**SYDNEY OLYMPIC PARK AUTHORITY  
DESIGN REVIEW PANEL  
ADVICE SHEET**

**Re: SITE 9 HOSPITAL DEVELOPMENT, SYDNEY OLYMPIC PARK**

<b>Project</b>	3.2 – Site 9
<b>Presentation / Review Date</b>	19 <sup>th</sup> July 2007
<b>Panel Present</b>	Peter Mould Philip Thalís Darlene van der Breggen (SOPA)
<b>COI Declaration</b>	nil
<b>Also Present</b>	Brian Newman (SOPA) Craig Bagley (SOPA) Steve Jensen (SOPA)
<b>Presenters</b>	Noel Samyia (PTW Architects)
<b>Documents made available</b>	PP presentation and A1 drawings
<b>Inherited decisions</b>	Existing DA for commercial office building
<b>Previous relevant SOPA Advice</b>	DRP Advice sheet – 21st June 2007.
<b>General Observations/ Overall Comment</b>	Many of the previous concerns had been addressed through substantial changes to the internal planning and external elevation treatments
<b>Positives</b>	The Panel supported: <ul style="list-style-type: none"> <li>• Structural changes that provide a covered colonnade along the Olympic Blvd frontage.</li> <li>• Plan amendments that reduce the building depth on the Sarah Durack frontage.</li> <li>• Incorporation of naturally ventilated break out spaces.</li> <li>• Façade detailing more closely re

BASEMENT 1

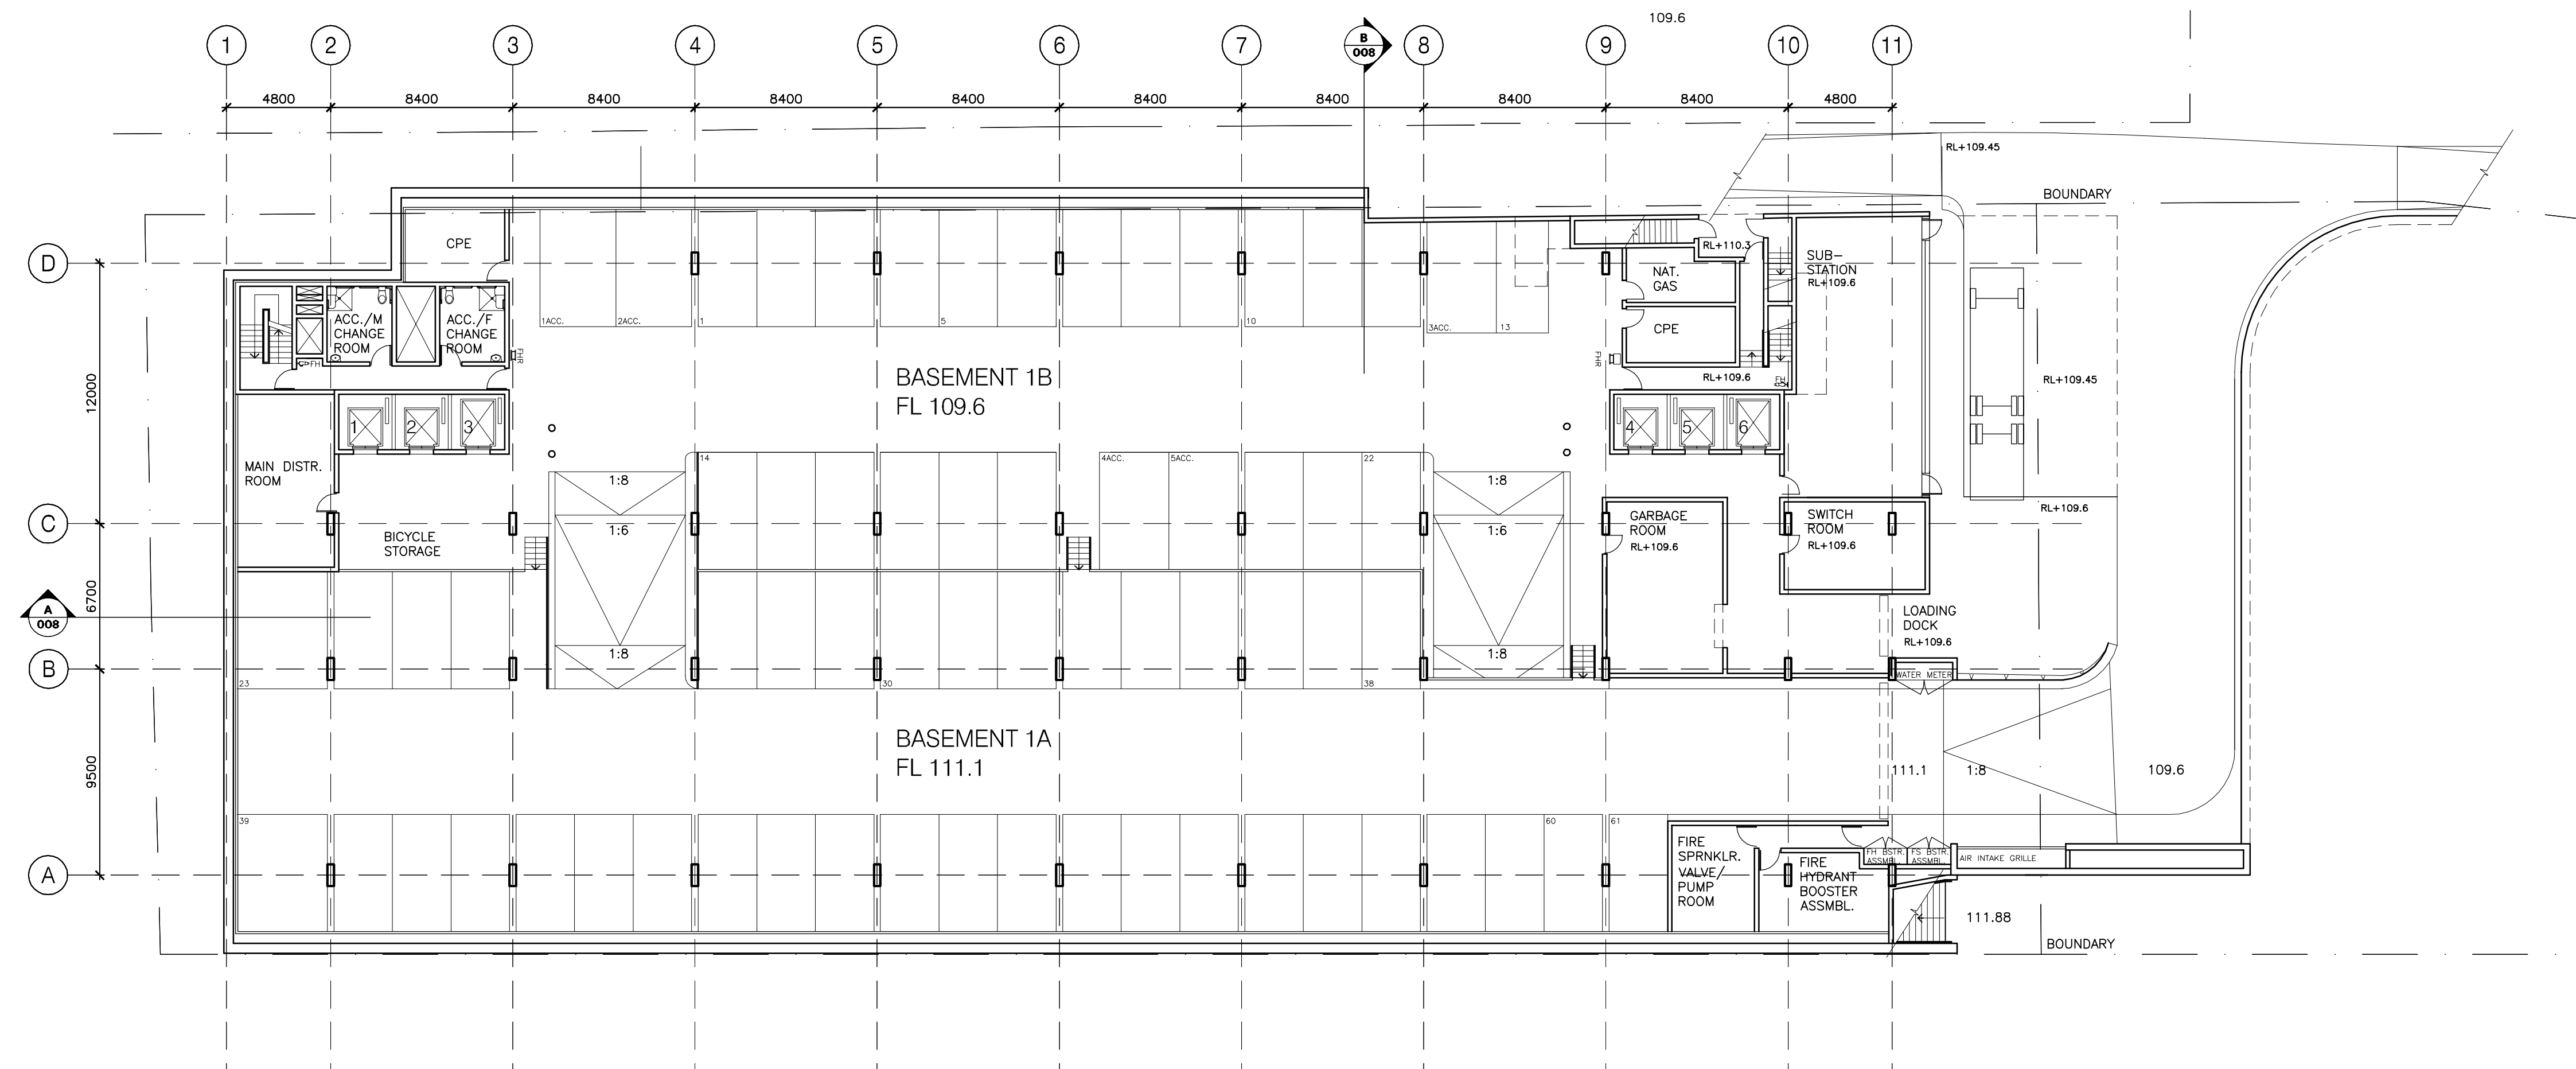
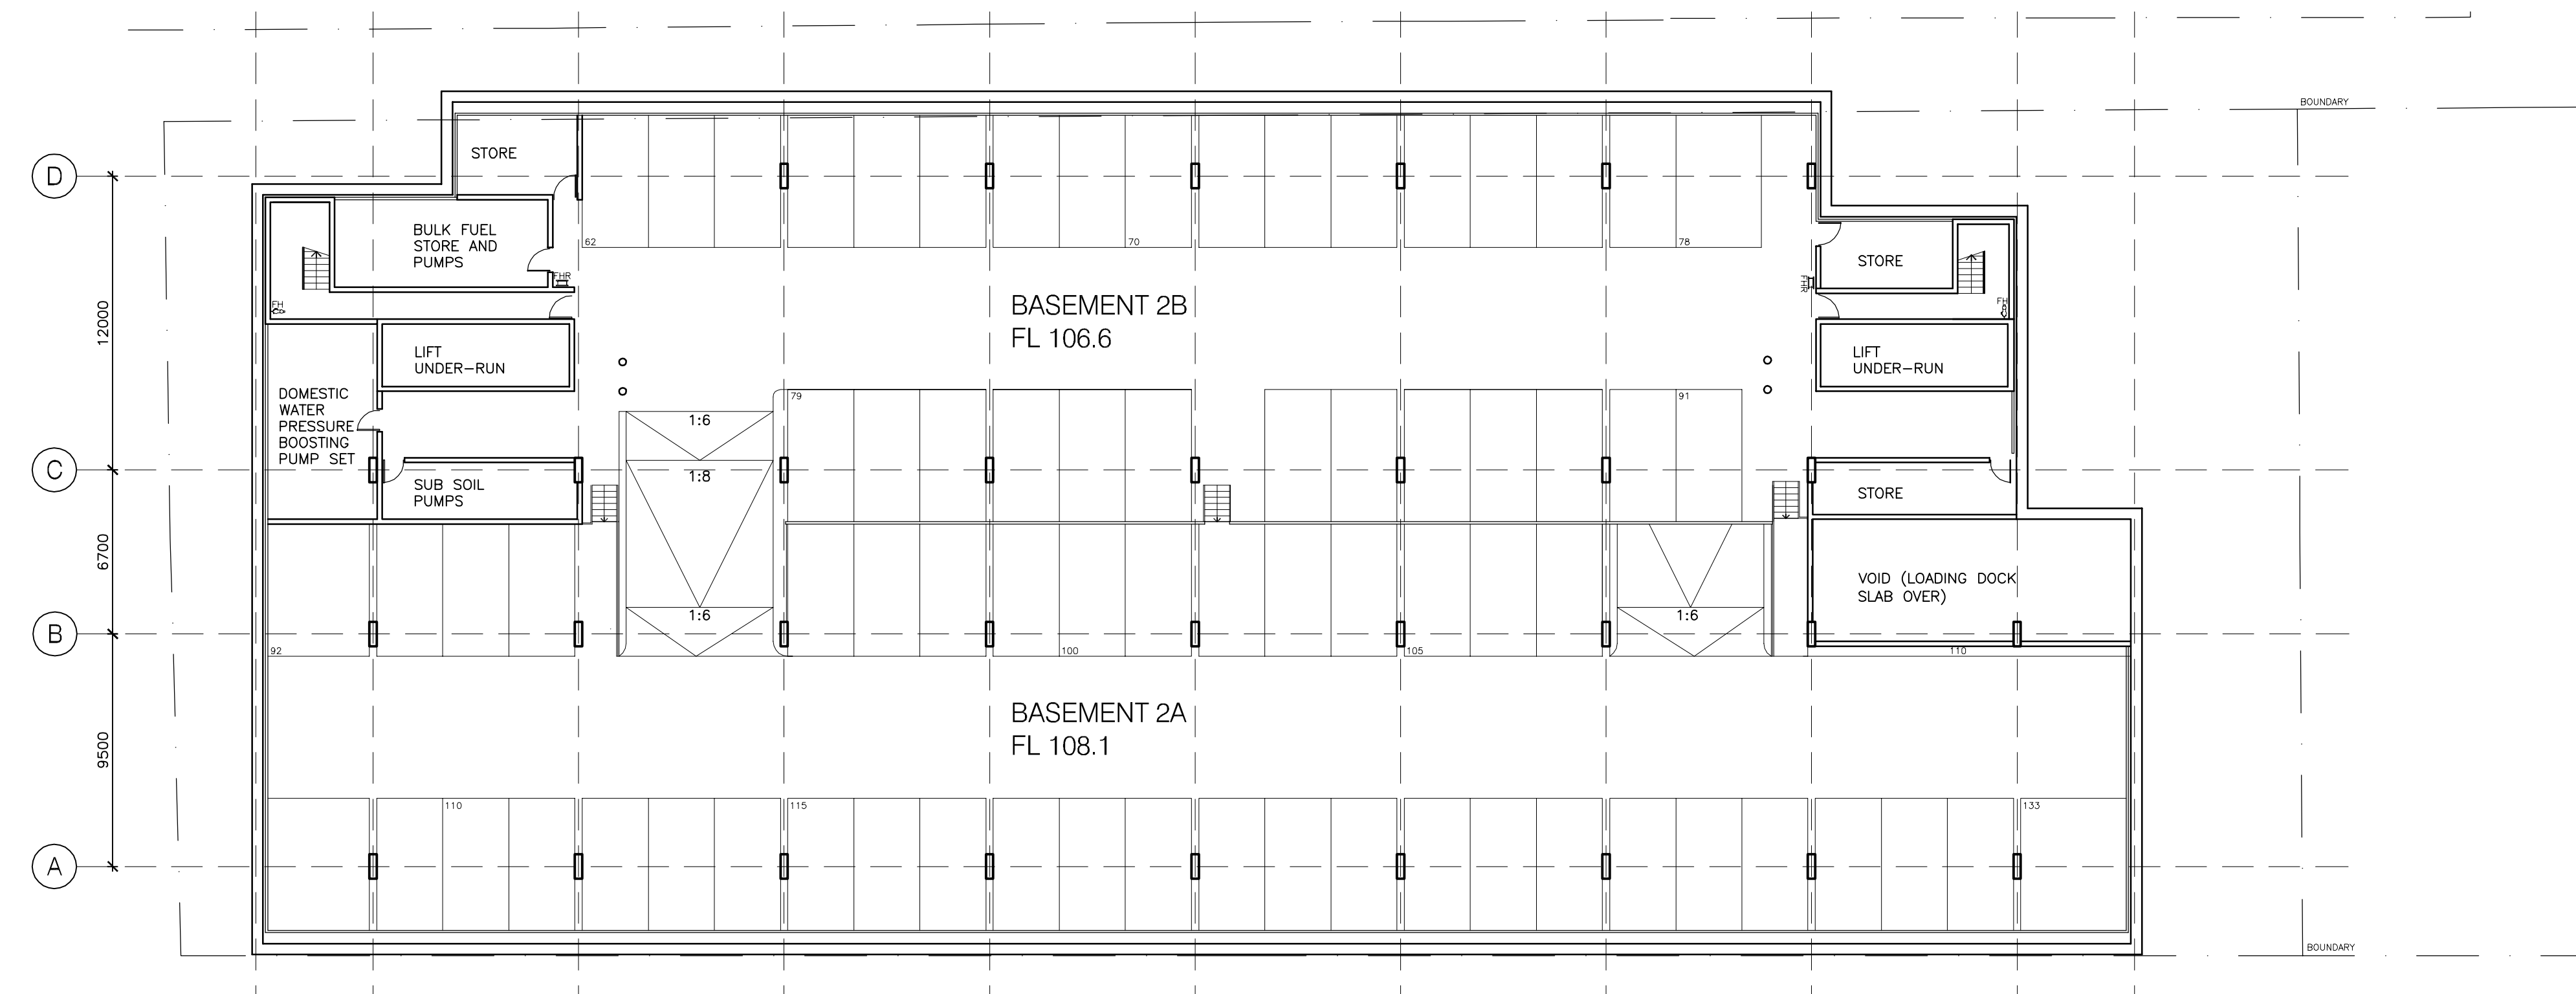
In reviewing the basement parking layout, we note that your current design provides for only 48 car parking spaces. This is inconsistent with the executed Agreement for Lease (refer our letter of 4 July 2007).

SOPA advises that it seeks the full compliment of parking spaces provided for in the AFL. To achieve this you may wish to consider excavating beyond the site boundaries as contemplated in the existing development consent.

SOPA have also agreed to allow the reduced number (54) of basement car parking spaces in accordance with the current layout.
